**KIRKLEES METROPOLITAN COUNCIL
INVESTMENT & REGENERATION SERVICE**

Reference No:	2023/62/90912/W
Site Address:	134, Deyne Road, Netherton, Huddersfield, HD4 7EP
Description:	Erection of single storey rear and side extension
Recommending Officer:	Tom Hunt

HOUSEHOLDER DELEGATED REPORT

client	MR AND MRS MAZZUCHELLI		
project	EXTENSION 134 DEYNE ROAD NETHERTON HUDDERSFIELD HD4 7EP		
drawing	PROPOSED PLANS		
revision	notes	date	drawn
scale :	1:50 AT A1	03.23	PB
project no.	2260	drawing no.	02

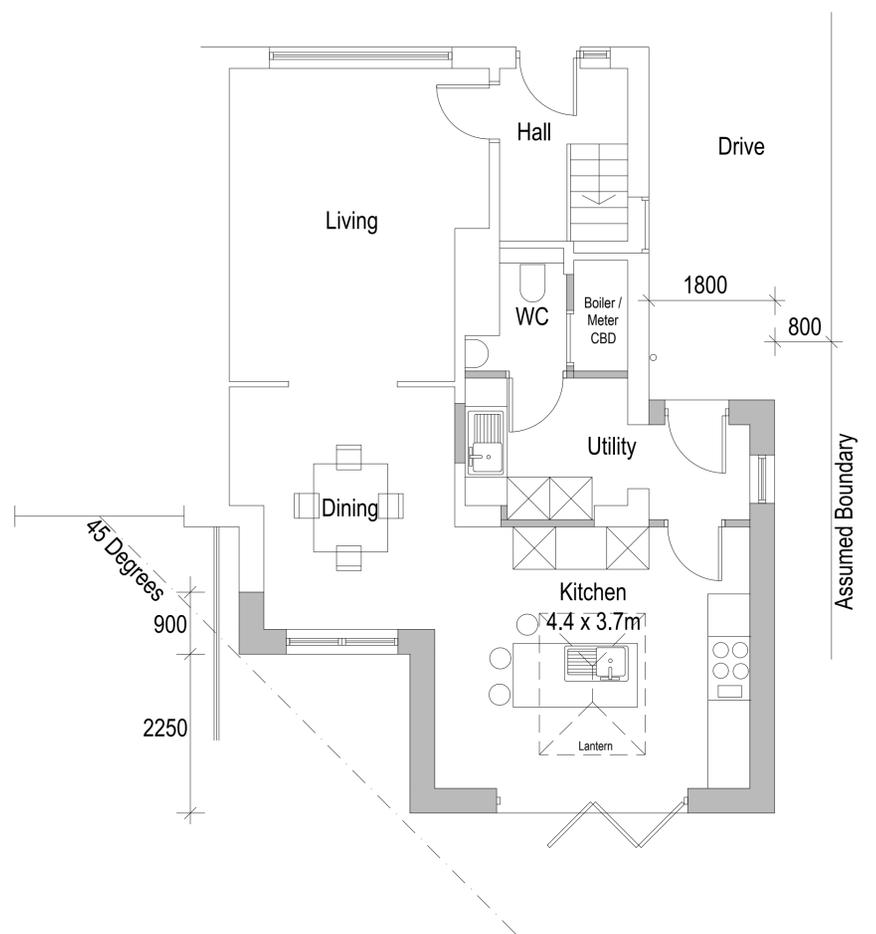
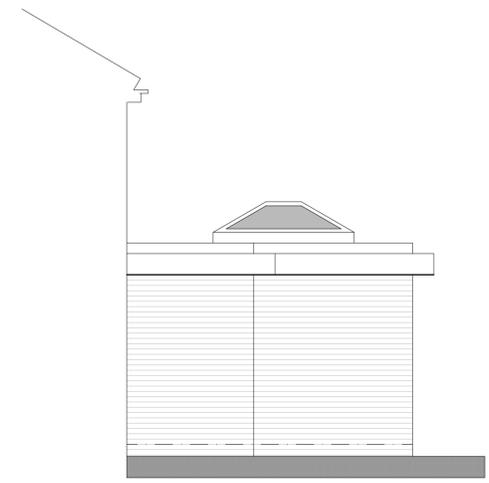
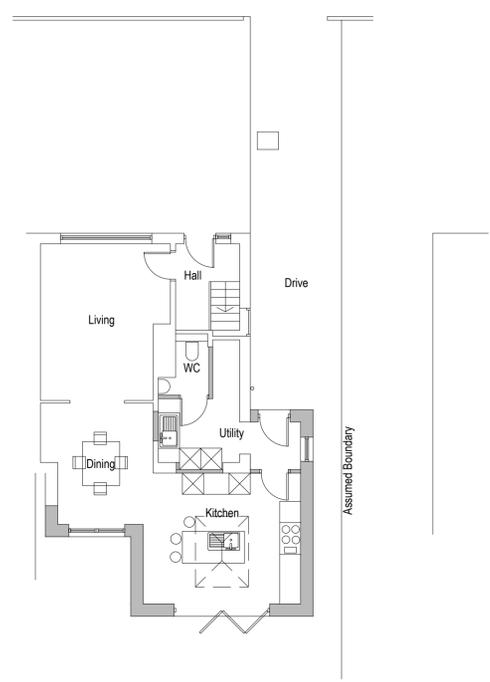
Negotiations/Amendments during course of application	Yes	Amended plans were requested to show the side elevation of the extension to assess potential impact on residential amenity.
Parish/Town Council comments sought	N/A	No comment received
Planning History	No	none
Consultations required	No

- No. 136 Deyne Road (side) – semi-detached neighbour with a large rear extension and a detached outbuilding. There would be one window facing the property's side elevation facing the blank wall of the rear extension. While the proposed block plan does not show the new extent of the rear extension, Officers can confirm that the rear extension would not protrude past the extension and would be of a similar height north of the neighbour ensuring that it would not appear overbearing or overshadowing.*

- No. 132 Deyne Road (side) – this is the attached neighbour. The proposed extension would be to the southwest of the neighbour and would extend a further 0.9m from the existing single-storey rear extension on the boundary; this has been demonstrated on plans to not impinge on the 45 field of outlook to the neighbour with a sensitive stepped design ensuring that it would not appear overbearing or significantly overshadowing the neighbour. Amended plans have confirmed that there are to be no windows facing this neighbour ensuring no overlooking or loss of privacy.*
